**RE:** Cherokee Subdivision

1304 Cherokee NW

Grading Plan Engineer's Stamp Date: 1/9/18

Drainage File: G14D089

ENGINEER'S SEAL DAVID SOULE P.E. #14522	CHEROKKE ROAD	DRAWN BY WCVJ
	GRADING AND DRAINAGE PLAN	DATE 1-07-17
1/12/18	 Rio Grande Engineering 1606 CENTRAL AVENUE SE SUITE 201 ALBUQUERQUE, NM 87106 (505) 872-0999	21845-LAYOUT-1-07-18
		SHEET #
		JOB # 21845

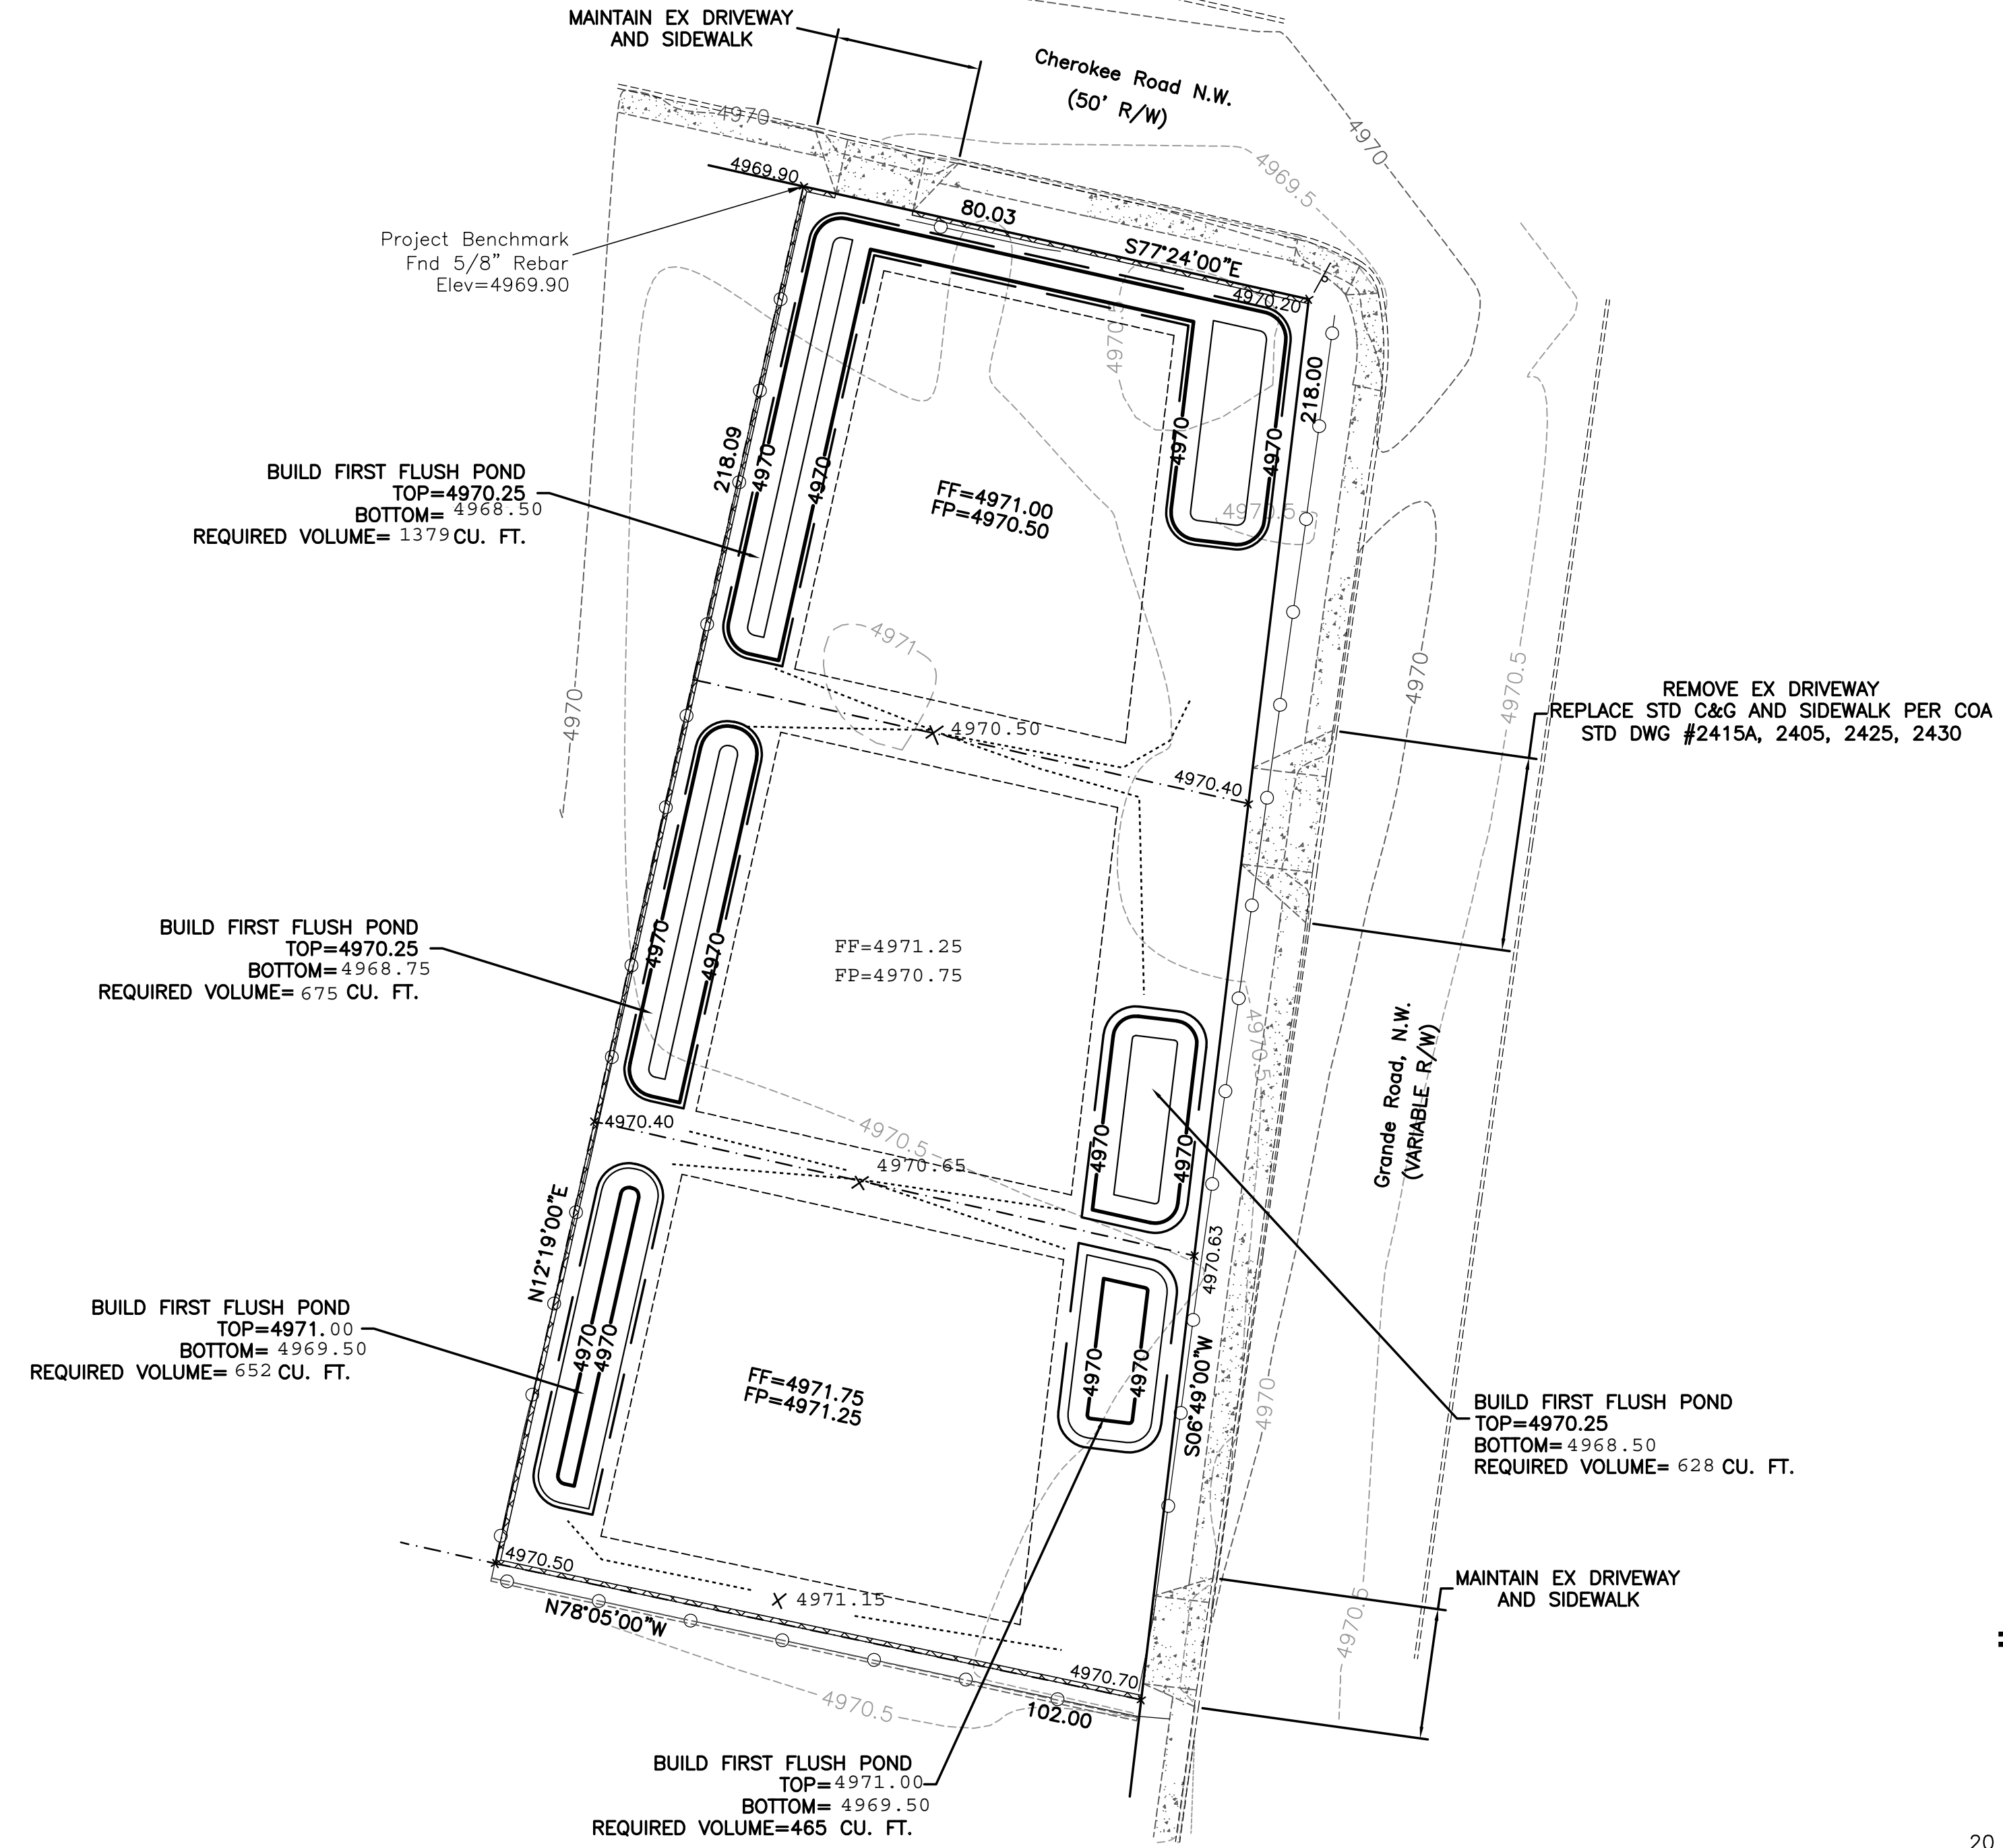
- 1. Provide onsite ponding volume on each lot for the 100-year, 10day volume; infiltration rates cannot be accepted in lieu of this volume requirement.
- 2. Please add swales along the side yards to direct runoff into the ponds.
